Re: Submission on Cabramatta Loop Project (SSI 9186)

Thank you for the opportunity to provide a submission on the above State Significant Infrastructure (SSI) project application. The project will comprise the construction and operation of a passing loop on the Southern Sydney Freight Line (SSFL). This is to enable freight trains, up to 1,300 metres long to pass each other and to travel in either direction.

Figure 6.1a The project

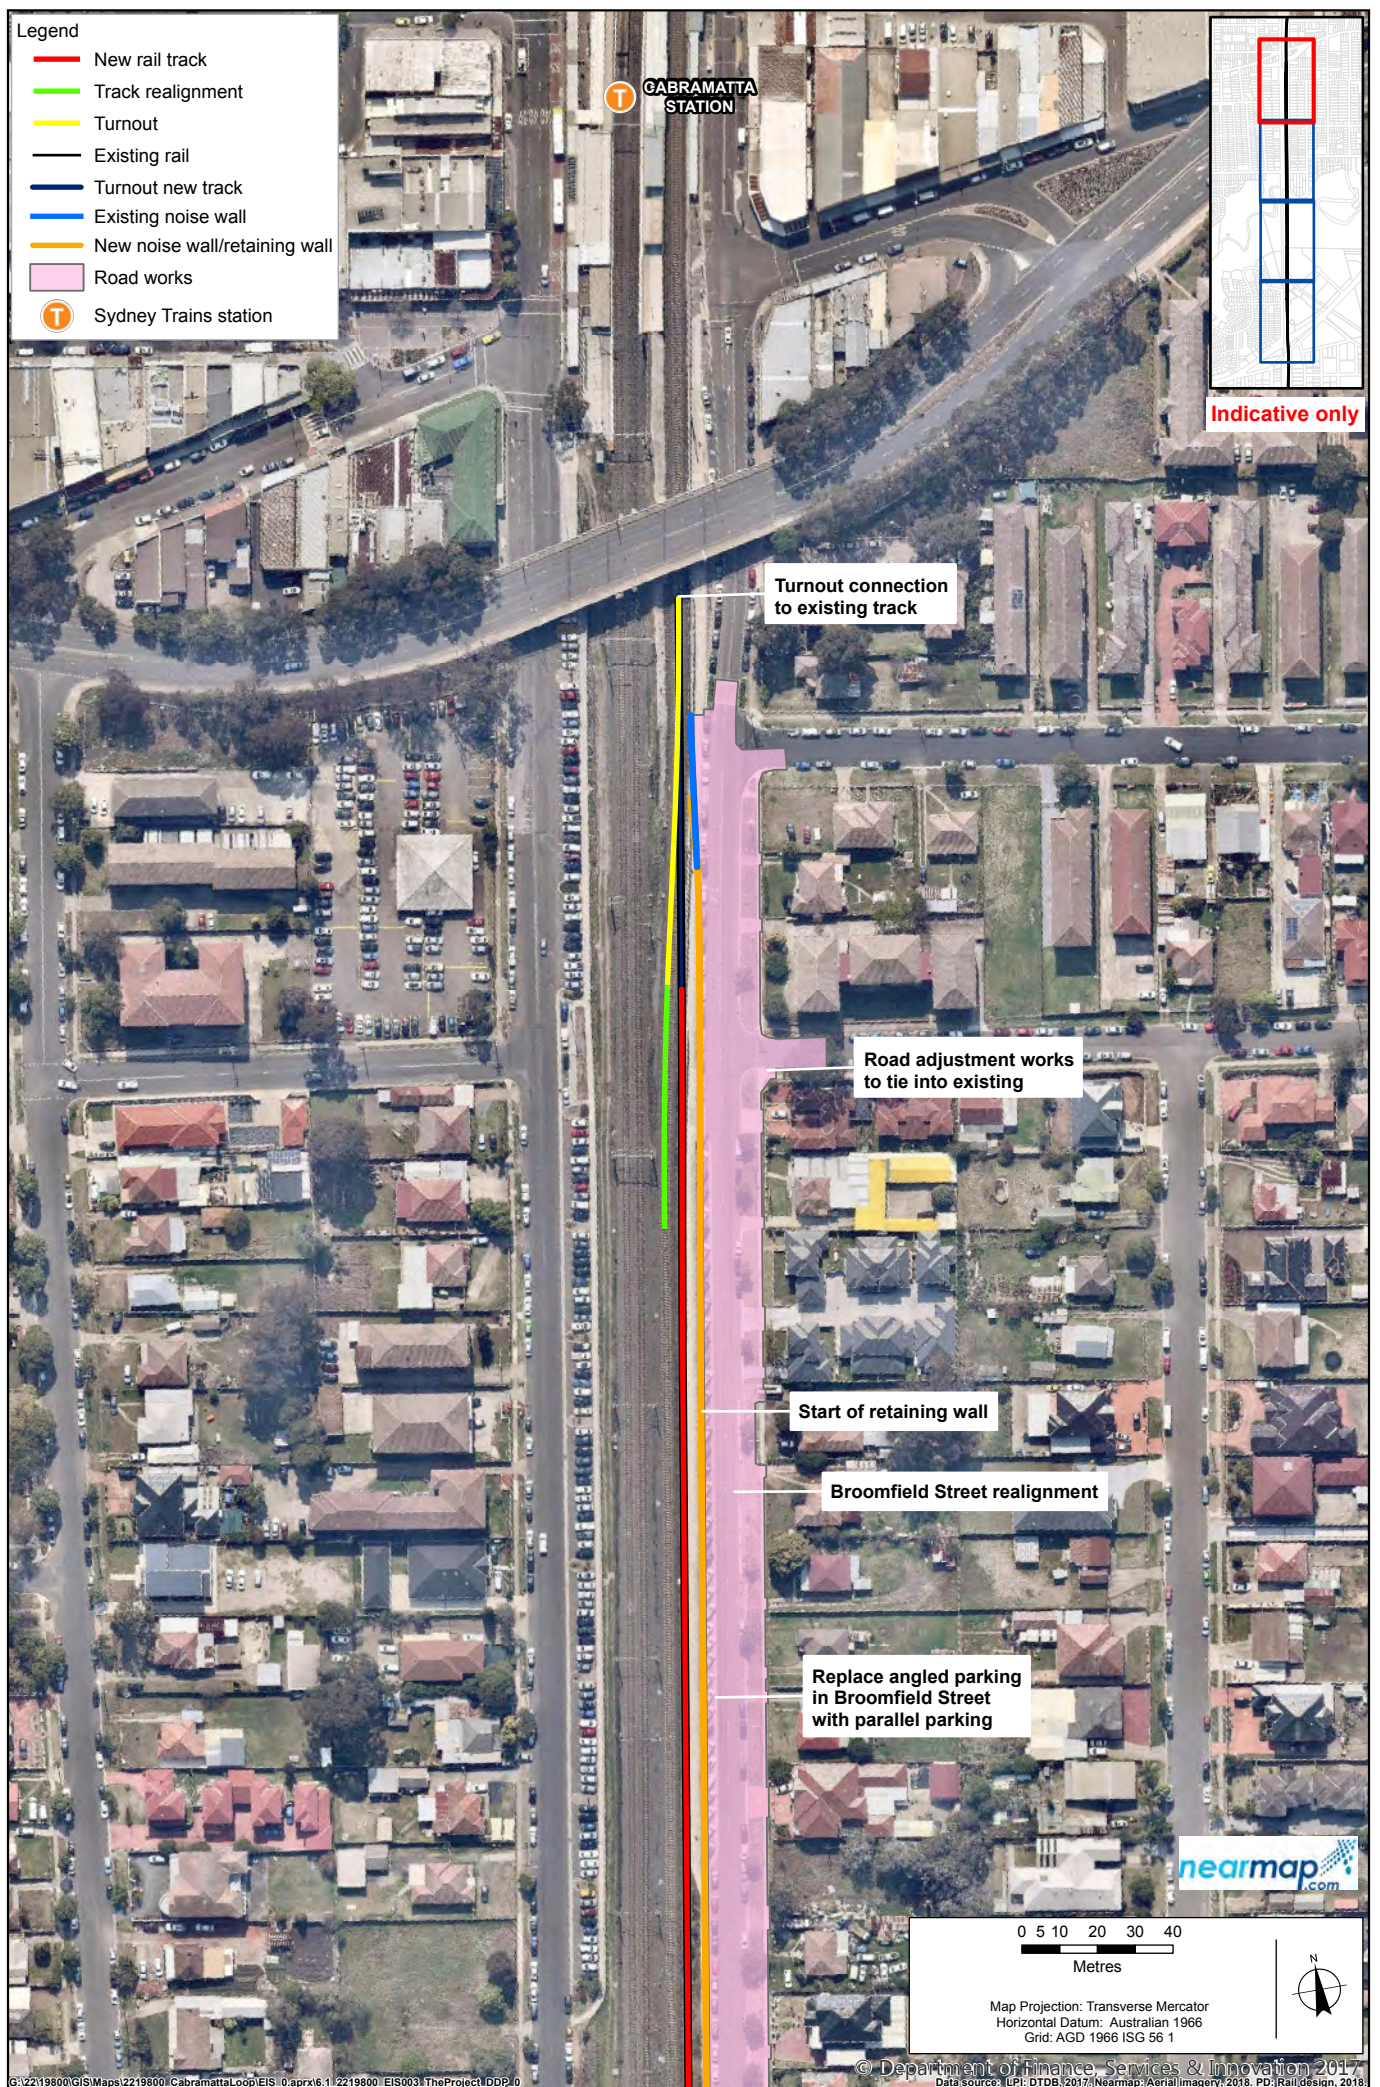
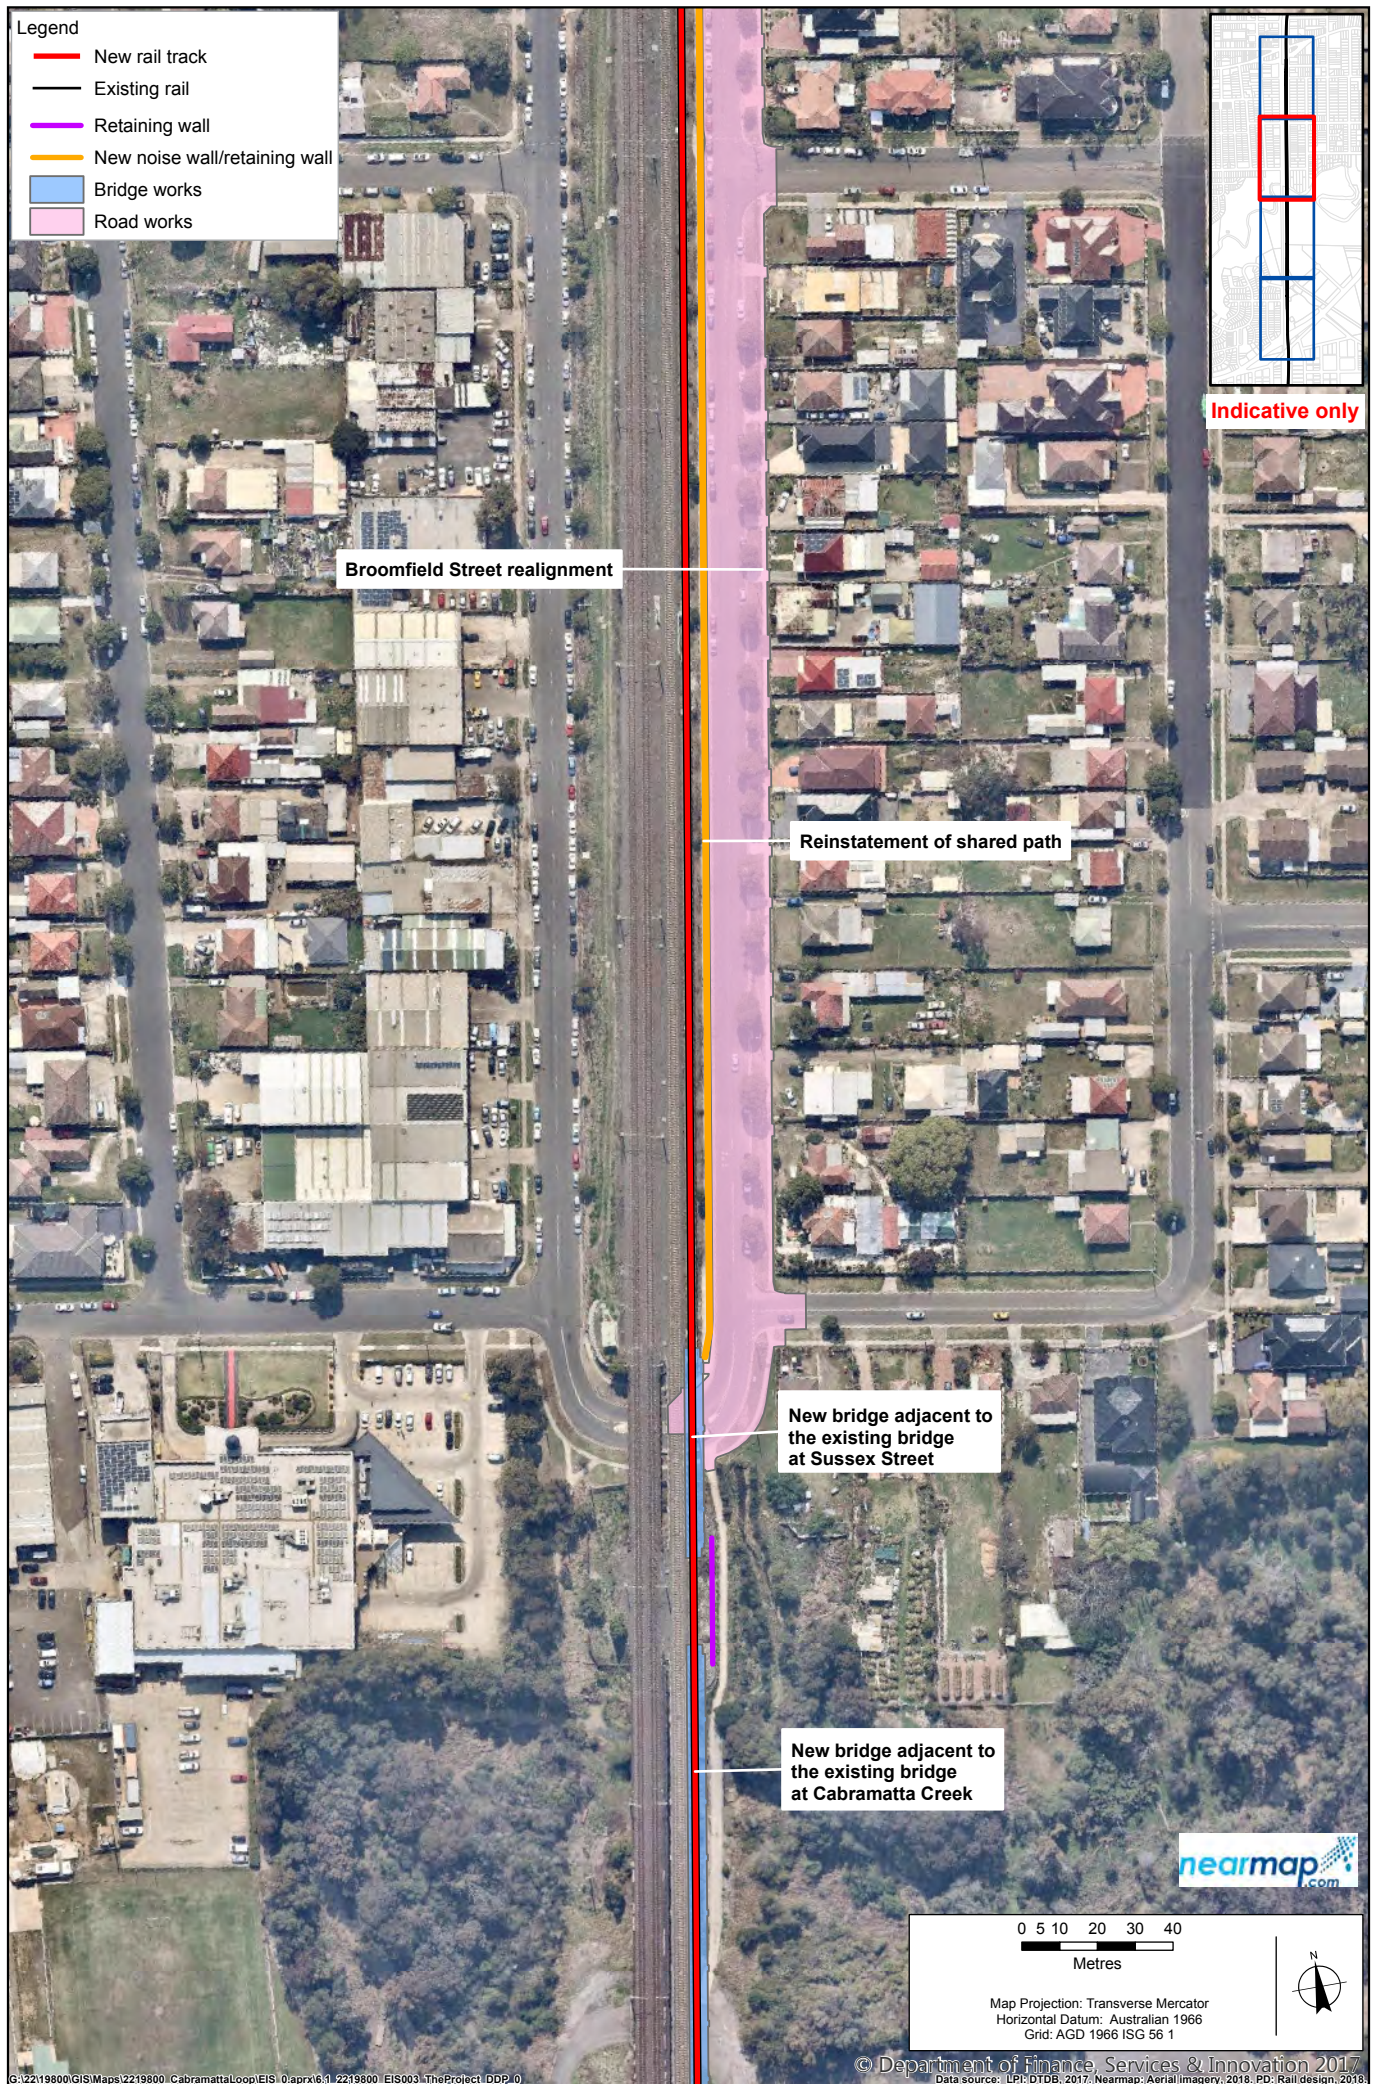
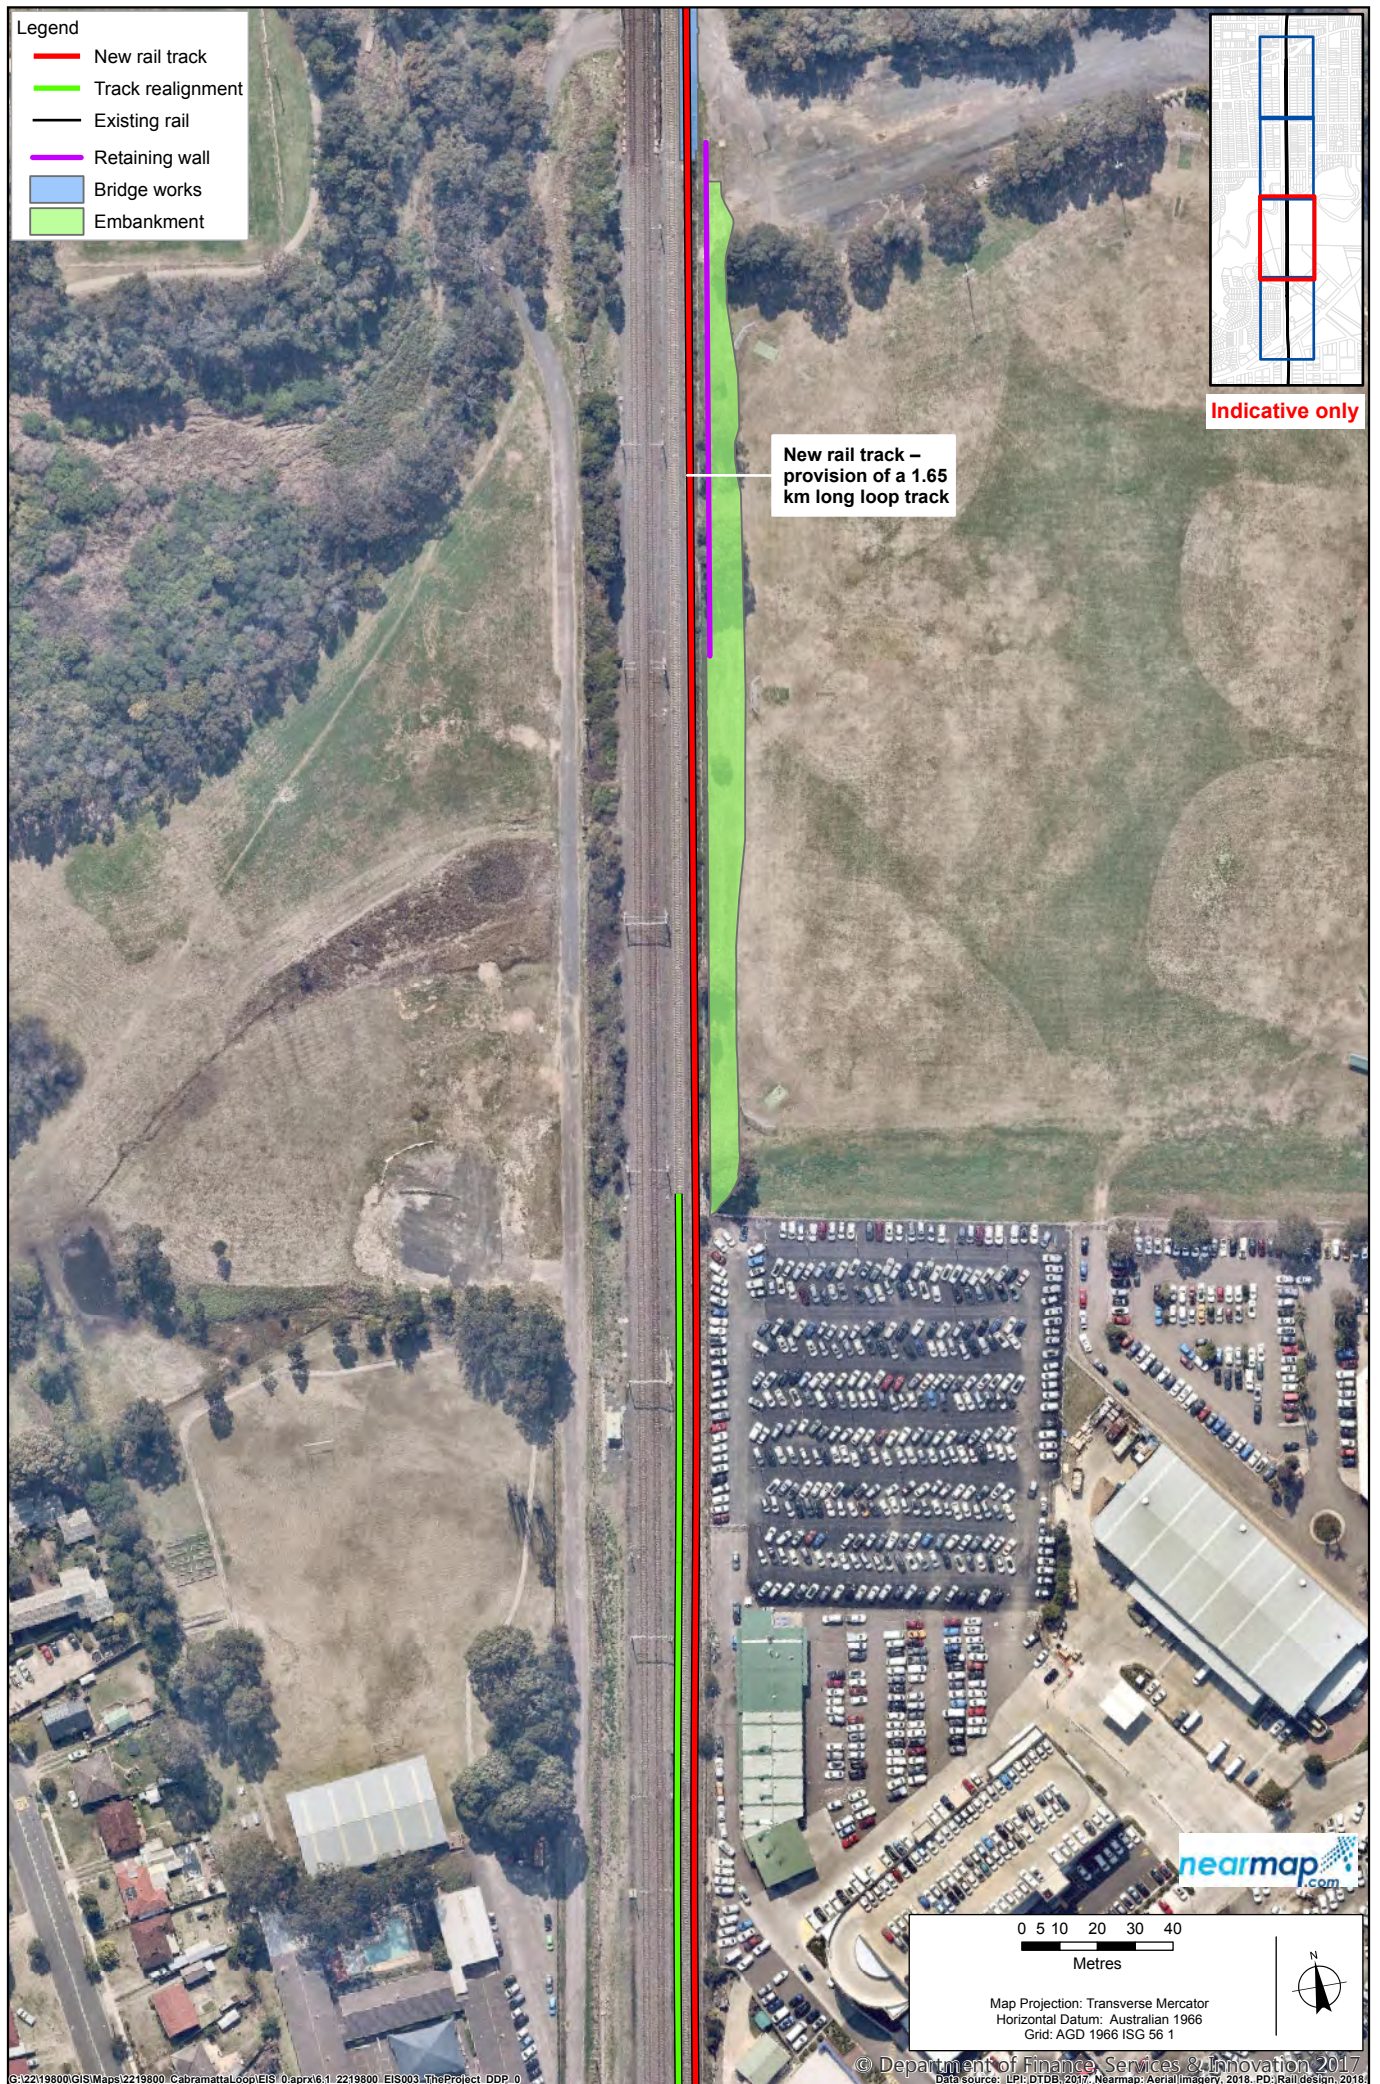
The project work site 'C3' proposed to be located within Jacquie Osmond Reserve, will impact 3 of the 12 softball diamonds available for use by the Southern Districts Softball Association. This will affect seasonal and event usage of these fields. The proposed permanent acquisition of a 5m strip of the reserve to the eastern side of the rail corridor will impact the softball diamond safety fencing, synthetic grass batting squares and the overall diamond dimensions. Pushing the three fields eastward will have a flow-on effect on the dimensions of remaining diamonds.

Removal of the existing shared path over Cabramatta Creek will require construction of a suitable replacement, which maintains connectivity between Station Street and Broomfield Street prior to the existing bridge being removed. Vehicular access to Jacquie Osmond Reserve will also need to be maintained at all times.
